06 September 2017

Our Ref VL/SPRUST(BROOKLANE).1
Your Ref A/11/17/OUT

**Land South of A259 New Road and East of Brook Lane, Angmering, West Sussex –
Planning Application A/11/17/OUT**

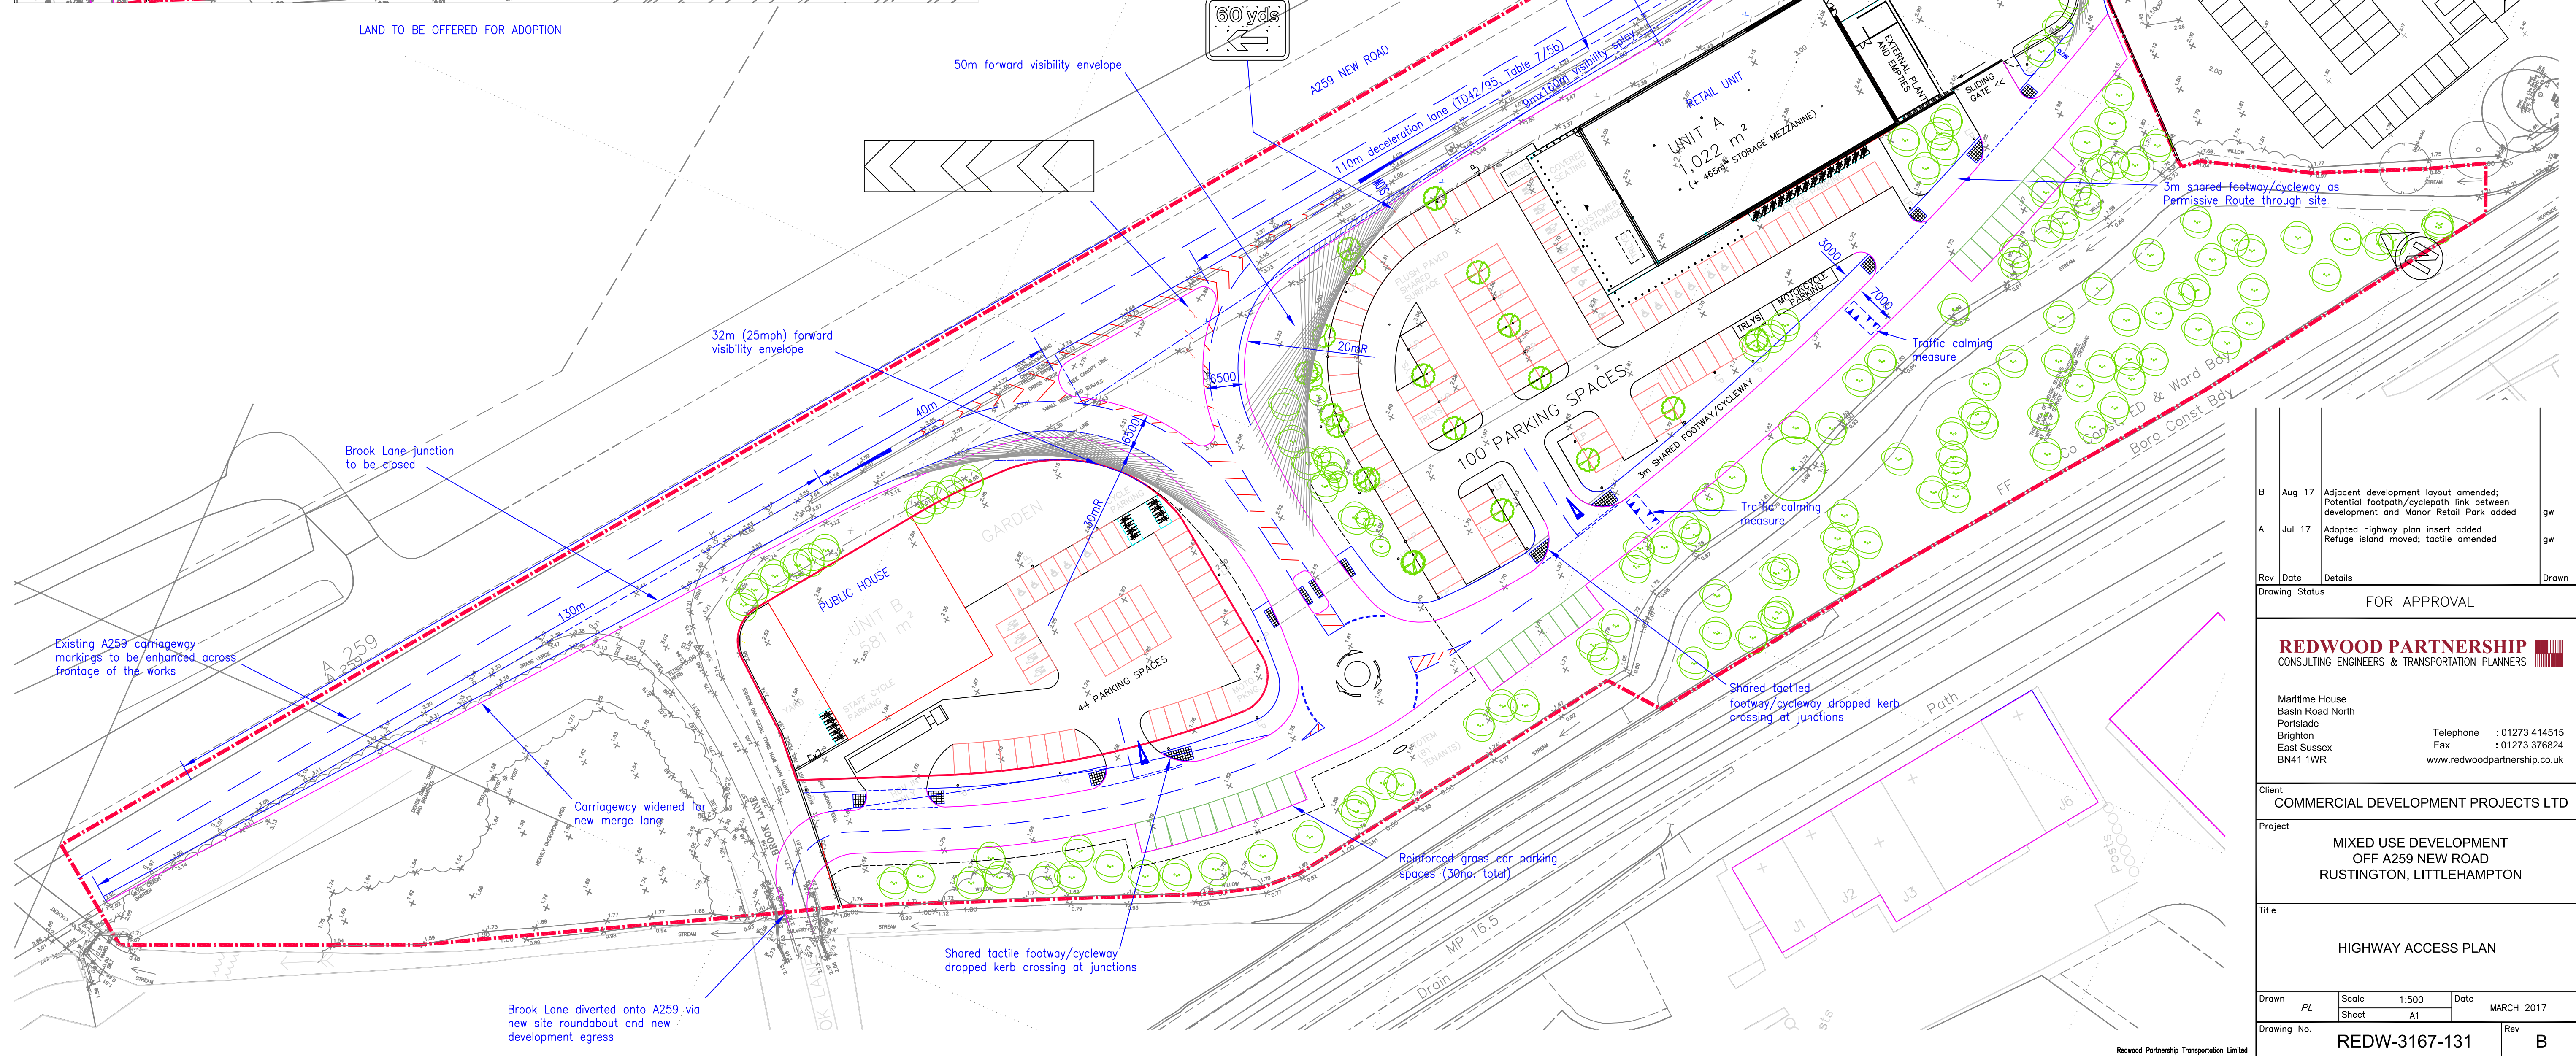
The proposed access arrangements are shown on Redwood Partnership's updated drawing number REDW-3167-131 Rev B. The Redwood Partnership's letter states that it would be necessary to close Brook Lane in order to implement this access. I therefore request, on behalf of our client Store Property Investments Ltd, should consent be granted that this requirement is conditioned. In addition, in the interests of highway safety, I request that no work should be allowed to commence on the development until it is known that the existing access to the A259 can be stopped up. The following condition is suggested:

The Made Order to secure the stopping up Brook Lane's existing access to the A259 should be obtained in advance of the commencement of the development. Brook Lane's access to the A259 should be stopped-up when the new access, as shown on Drawing REDW-3167-131 Rev B, is brought into use.

In the Redwood Partnership's letter of 2nd August it is stated that they are working with West Sussex County Council to agree the principle of the Highway Authority adopting the site access, mini roundabout and public house access road in order that Brook Lane can be diverted. However, this has been written in the full knowledge that West Sussex County Council have already rejected this proposal. In their consultation response dated 19th July, West Sussex County Council advised that they would only adopt the left-in/left-out access at the A259 and that they would not adopt the internal roads. This would result in occupants of Brook Lane having to pass through third party land to obtain access to the adopted highway at the A259. This arrangement is not acceptable to our client, Store Property Investments Ltd.

is contorted and narrows severely where it joins Brook Lane. Diverting Brook Lane, as proposed, would not provide a safe and suitable access.

The revised Redwood Partnership's drawing, REDW-3167-131 Rev B, confirms that the proposed layout would permanently prevent vehicular linkage between the application site and Manor Retail Park. As set out in my letter of 2nd August 2017, this is contrary to the NPPF. Our client has already confirmed, in their email dated 13th July, that the application site has full legal rights to access through Manor Retail Park.

Based on the above I request, on behalf of our client, that the implications of the proposed access arrangement are considered further. As currently proposed the access arrangements could not be implemented as the development relies on the stopping up and diversion of Brook Lane, which is not acceptable to our client.
